19 July 2012

**Shoalhaven Starches Bomaderry
Modification Application (MP06_0228 MOD 3)**

I refer to your letter dated 28 June 2012 seeking comments concerning the proposed modification relating to the Shoalhaven Starches Expansion Project. The proposal is to incorporate an additional lot into the project approval and relocate the approved staff car park to that lot with access to Bolong Road.

PLAN SHOWING PROPOSED TRAFFIC ARRANGEMENTS  
REDUCTION RATION 1:500

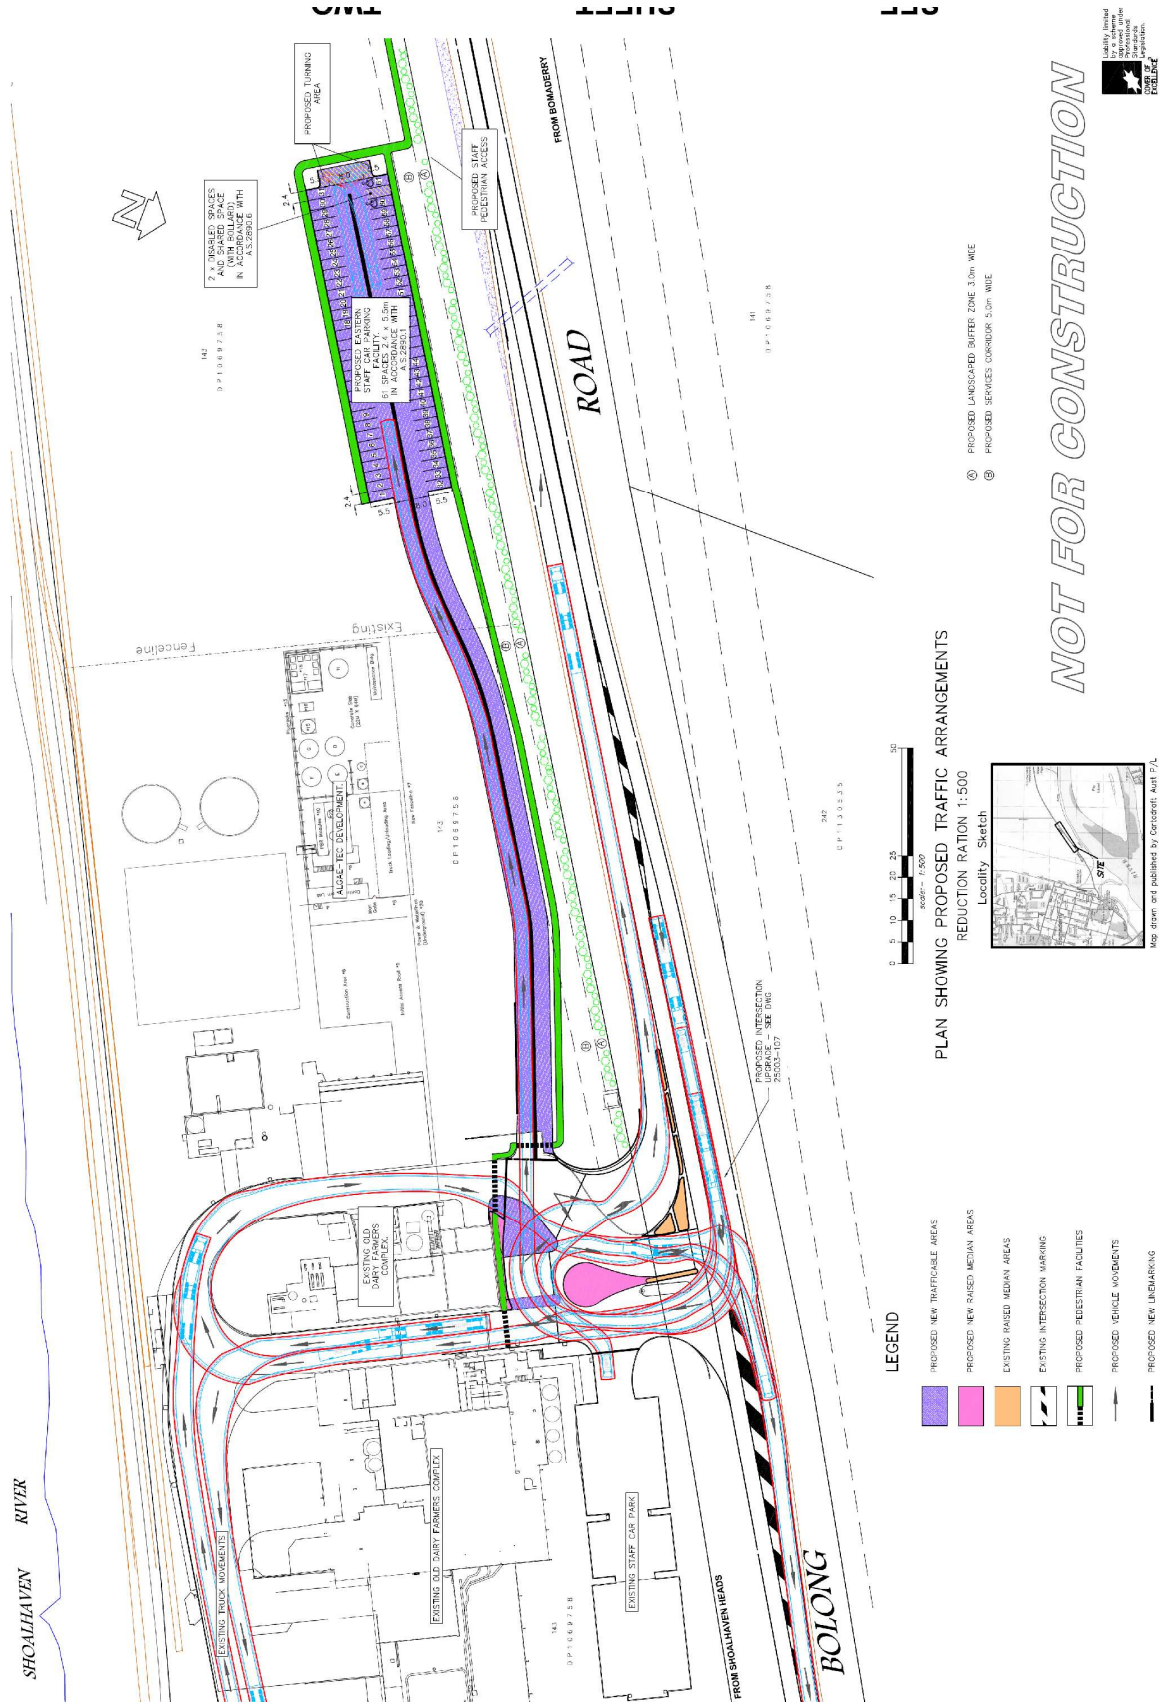
The proponent has indicated the car park will be designed to comply with AS2890 in all respects and this is supported. Appropriate line marking and internal signage should be installed to mitigate conflicts between cars and trucks using the common access and manoeuvring areas.

Car parking spaces are proposed to be the very minimum width under Australian Standards, although the aisle width proposed is considerably wider presumably to compensate for this. Further, we note the ARC traffic study recommends provision of a suitable turnaround area at the western end of the car park which is supported. Provision should be made for at least 2 spaces that meet the additional requirements for people with a disability.

- The ARC traffic impact study recommends a footpath connecting the new car park to the existing footpath adjacent AP1, and that pedestrian paths within the site be reviewed. The plan showing extent of footpath works is generally agreed. Accordingly modification approval should have an appropriate condition as follows:

- The use of the Dairy Farmers access as a defacto turnaround area was only approved by Council and RMS on a trial basis. Works under this modification will further reinforce the Dairy Farmers access as a more permanent turnaround arrangement which relocates turning movement conflicts into a higher speed zone. Physical works must be undertaken to provide greater appearance of the 60kph speed zone environment, if to achieve greatest benefits from the relocation of the 60/100 speed zone change, and following preliminary discussions this position is supported by RMS and formed part of their consideration of relocation of the speed zone. Accordingly modification approval should have an appropriate condition as follows:

- Re the internal turnaround island inside the Dairy Farmers access; this requires construction as a physical (raised) facility, accordingly modification approval should have an appropriate condition as follows:

“A suitable turnaround facility is to be provided at the western end of the car park to facilitate safe efficient turnaround for those vehicles that could not find a car park”; and

“Applicant is to consider providing an overflow car parking area (gravel all weather surface) at the western end of the car park to accommodate overflow car parking on site.”

“Extend the existing footpath on Bolong Road (southern side) from the AP1 access, continuing east to a location adjacent the eastern extent of the new car park, and provide a gated access at the boundary and footpath connection to the car park, to the satisfaction of Council including provision of appropriate lighting of the pedestrian pathway in accordance with standards”;

“Extend the existing median from the eastern side of the AP1 access, continuing east to the location of Dairy Farmers access, terminating to the eastern side of the Dairy Farmers access, leaving a minimum gap at the Dairy Farmers access only, sufficient to accommodate turning movements at the Dairy Farmers access only, to the satisfaction of Council and RMS. The median shall be of minimum 900mm width for most of the mid-block length (between AP1 and Dairy Farmers access) however will taper to increased width to accommodate the physical channelization required as part of the CHR / CHL designs to the satisfaction of Council and RMS”; and

“In regards to the proposed turnaround island immediately inside the Dairy Farmers Access the applicant is to construct this island as a physical (raised) treatment to the satisfaction of the Local Shoalhaven Traffic Committee.”
